Application No: K/54/21/PL  
Site Address: Moorings Gorse Avenue East Preston BN16 1SQ  
Description of works: Variation of condition imposed under K/58/20/HH relating to condition 2-approved plans.

Thank you for your internet representation made on 16th December 2021 which has been recorded as an objection with the comments as follows:

Drawing no. **KG/GA/06**

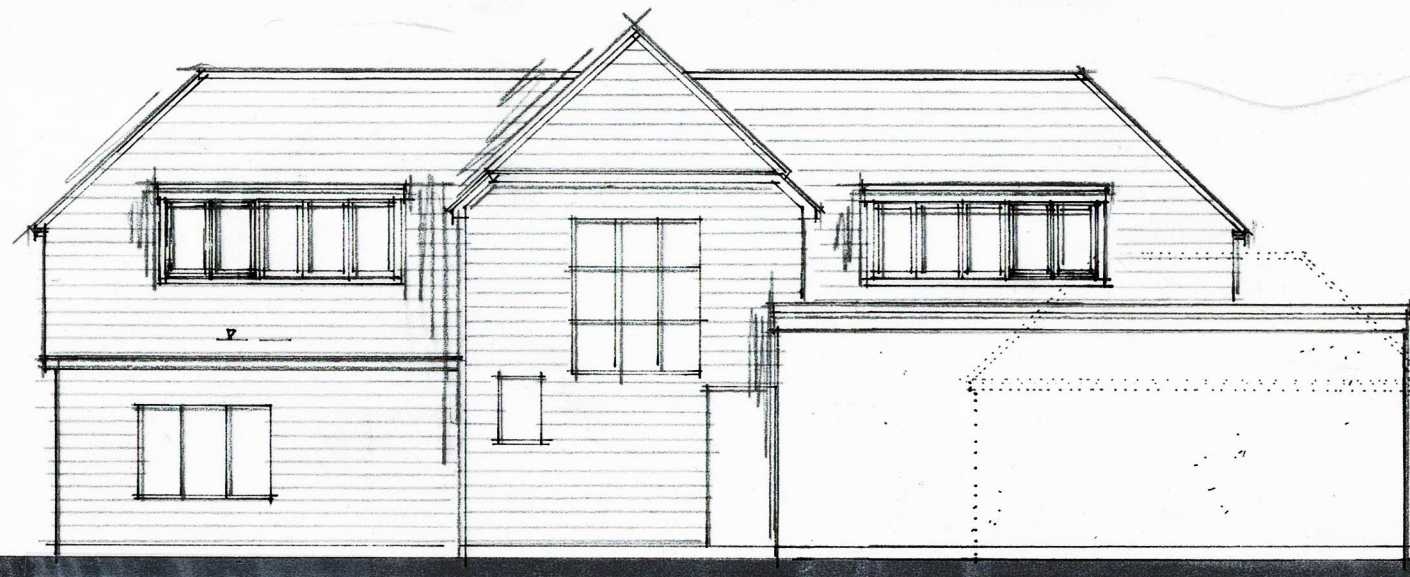
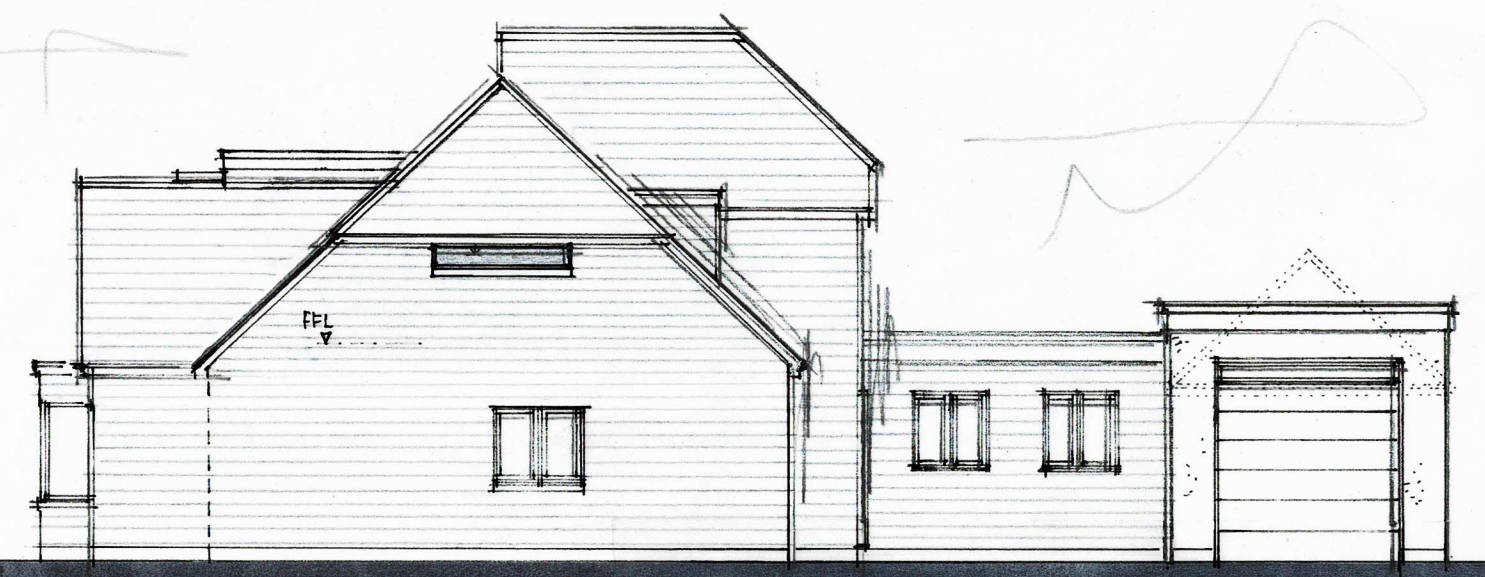
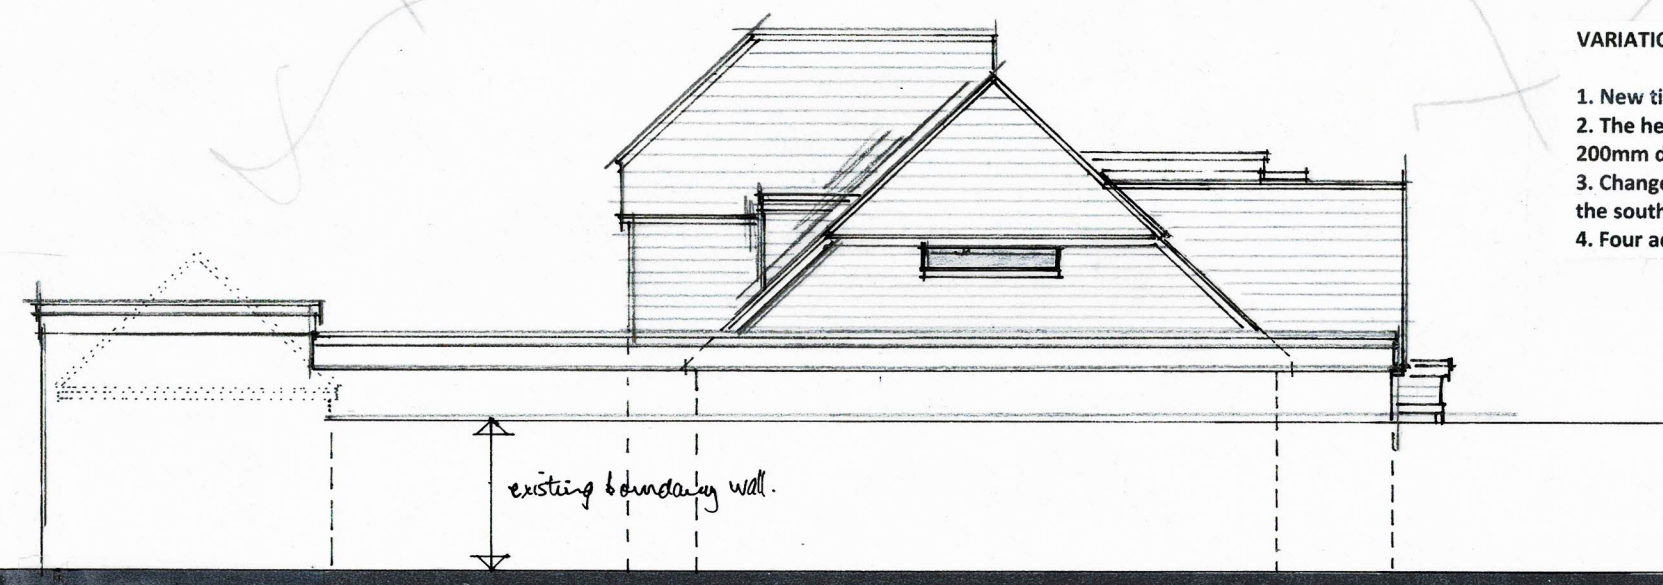
The west first floor bedroom will have a large dormer window to the front, and if approved, two south facing velux roof lights. The approved west facing window to this room already results in visual intrusion and loss of privacy for the occupiers of Highwater House. There is no justification for any increase in the size of this window, bearing in mind sufficient approved fenestration. Notwithstanding there is no reference in the application that the proposed window will include a fixed non-opening unit with OBSCURE glass. The addition of gable glazing and roof lights facing south will also result in unacceptable visual intrusion of the rear garden to Highwater House. There is no reference to the suitability of timber shingles in place of clay tiles in terms of fire resistance.
